# TIMBERS AT BLACK FOREST MAP AMENDMENT (REZONE)

A PORTION OF THE SOUTHWEST QUARTER  
SEC. 22, T12S, R65W OF THE 6TH P.M., COUNTY OF EL PASO, STATE OF COLORADO

TIMBERS AT BLACK FOREST MAP AMENDMENT (REZONE)

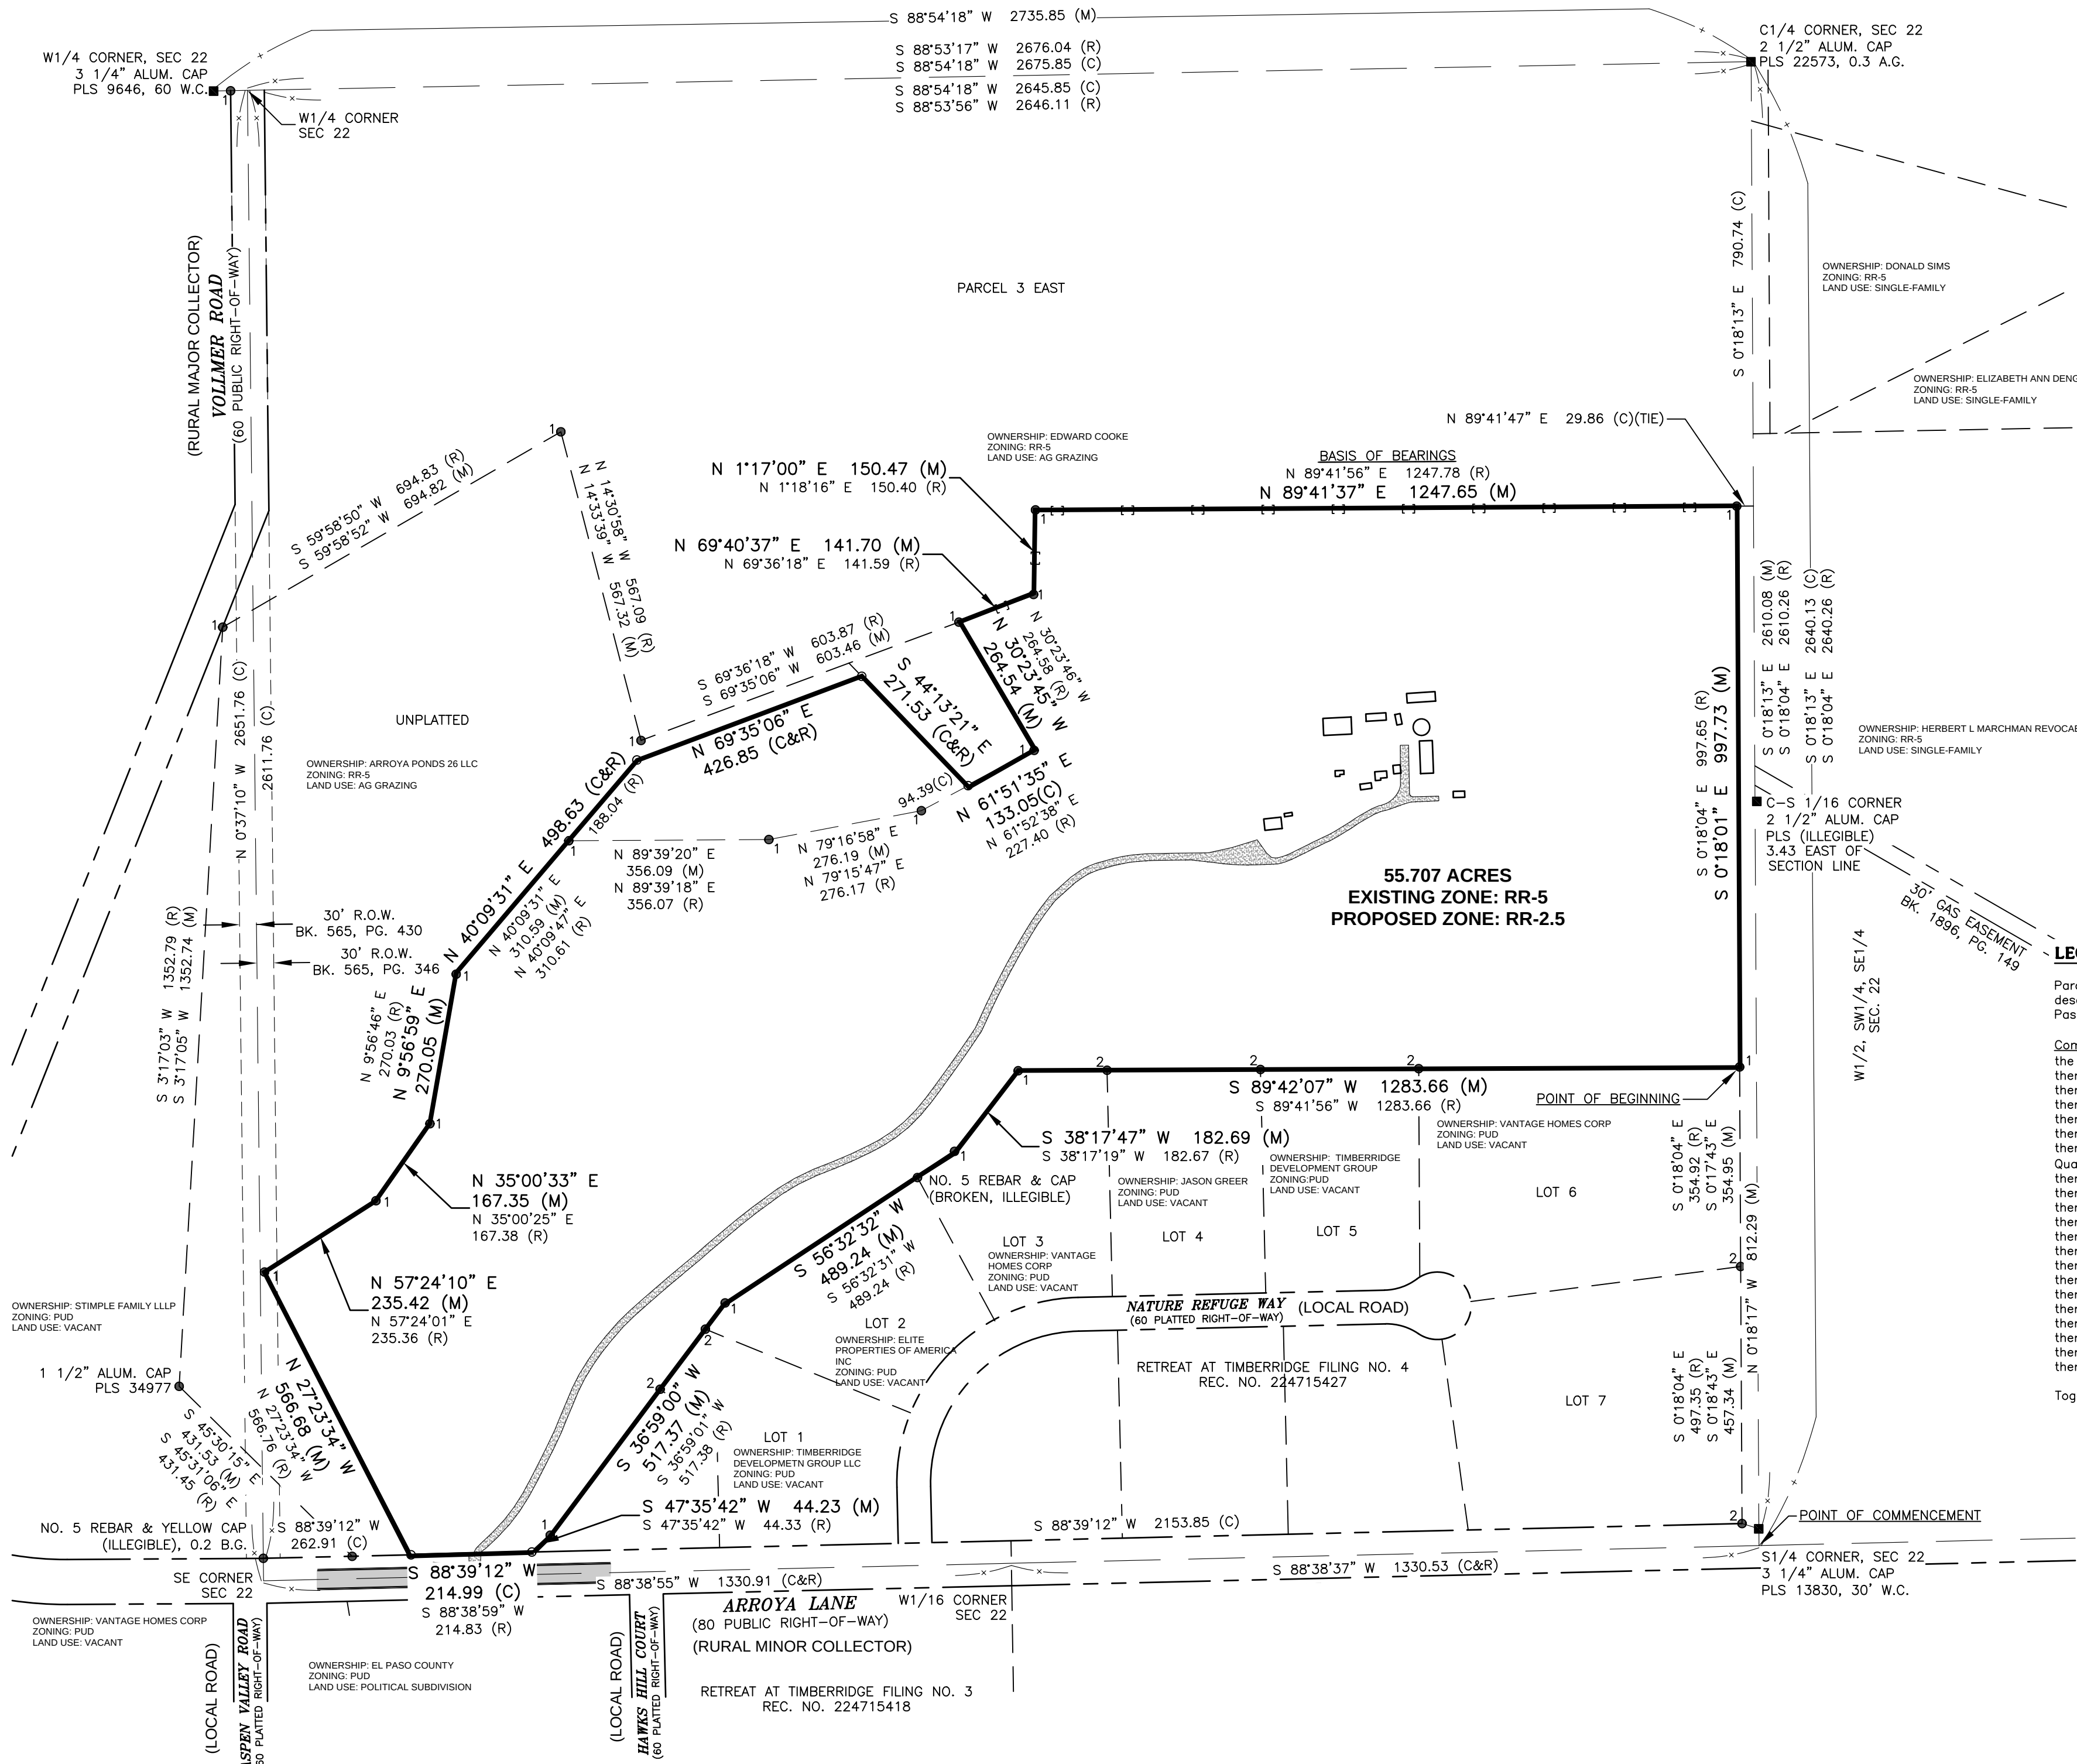
Adj property lines do not appear up to date- there are 3 parcels I believe

Response: Deeds and survey emailed to EPC on 9/1/26 demonstrating the configuration matches what is depicted on the zoning map. We understand the assessor database has not yet caught up.
